Application Ref:	3/2025/0814			 Ribble Valley Borough Council www.ribblevalley.gov.uk
Date Inspected:	11/11/25	Site Notice:	11/11/25	
Officer:	LW			
DELEGATED ITEM FILE REPORT:				REFUSAL

Development Description:	Proposed open sided car port.
Site Address/Location:	Startifants Farm, Goose Lane, Chipping, PR3 2QB.

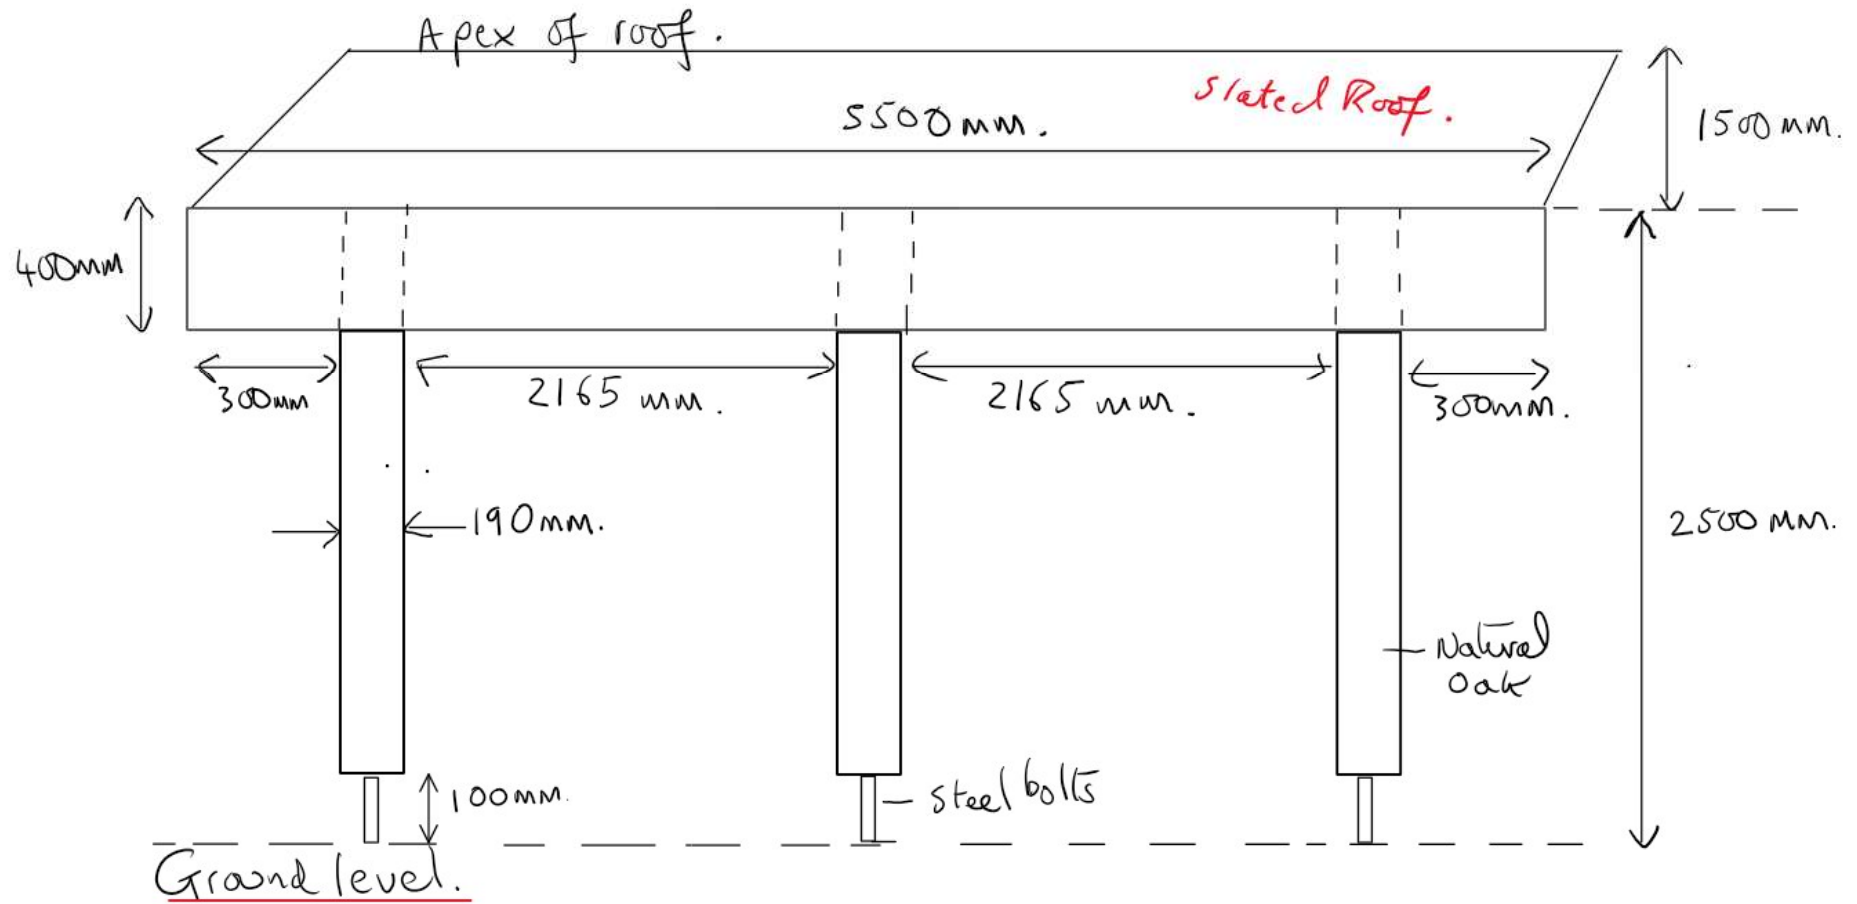
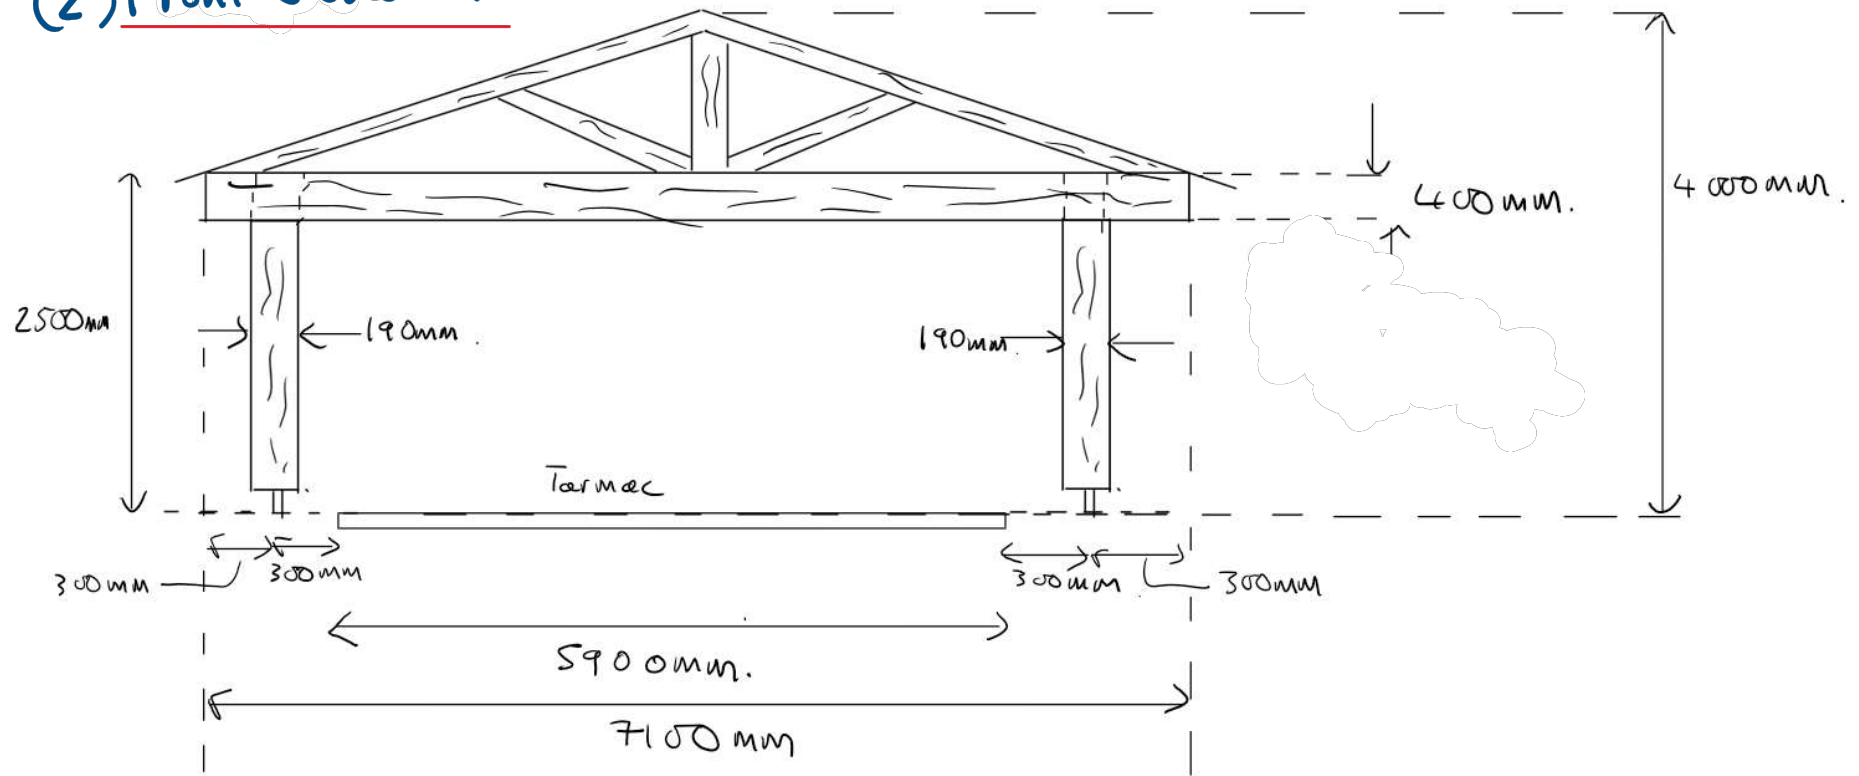
The car port would measure a maximum of 7.1m by 5.5m with an eaves and ridge height of 2.5m and 4.0m respectively and would be constructed with a natural oak frame and slate roof.

The proposed development comprises a double car port with a footprint measuring 7.1m by 5.5m and a pitched roof with a height of 4m. Whilst the dimensions and overall design of the proposal are considered appropriate for its intended use, the development would occupy a highly prominent location, forward of the principal building line of the application property and adjacent to the public highway, separated from the main dwellinghouse by the aforementioned driveway. Although it is noted that the existing boundary hedgerow and trees would provide some degree of visual screening, views of the development would still be afforded from the adjacent public realm, particularly in the winter months when the vegetation thins, as well as from the two access points serving the driveway. The development would therefore have a clear visual impact upon the adjacent public realm, with its size, scale and prominent siting being such that it would adversely affect the proposal site's spacious qualities of detriment to the National Landscape.

Taking the above into account, the proposed development by virtue of its size, scale and siting would result in the introduction of a form of development which would appear discordant and unsympathetic when viewed in context with the existing spatial arrangement of the proposal site by virtue of its prominent siting forward of the principal building line. The development would therefore be of detriment to the existing visual amenities of the street scene and the wider National Landscape, contrary to the aims and objectives of Key Statement EN2 and Policy DMG1 of the Ribble Valley Core Strategy and Paragraph 135 of the National Planning Policy Framework.
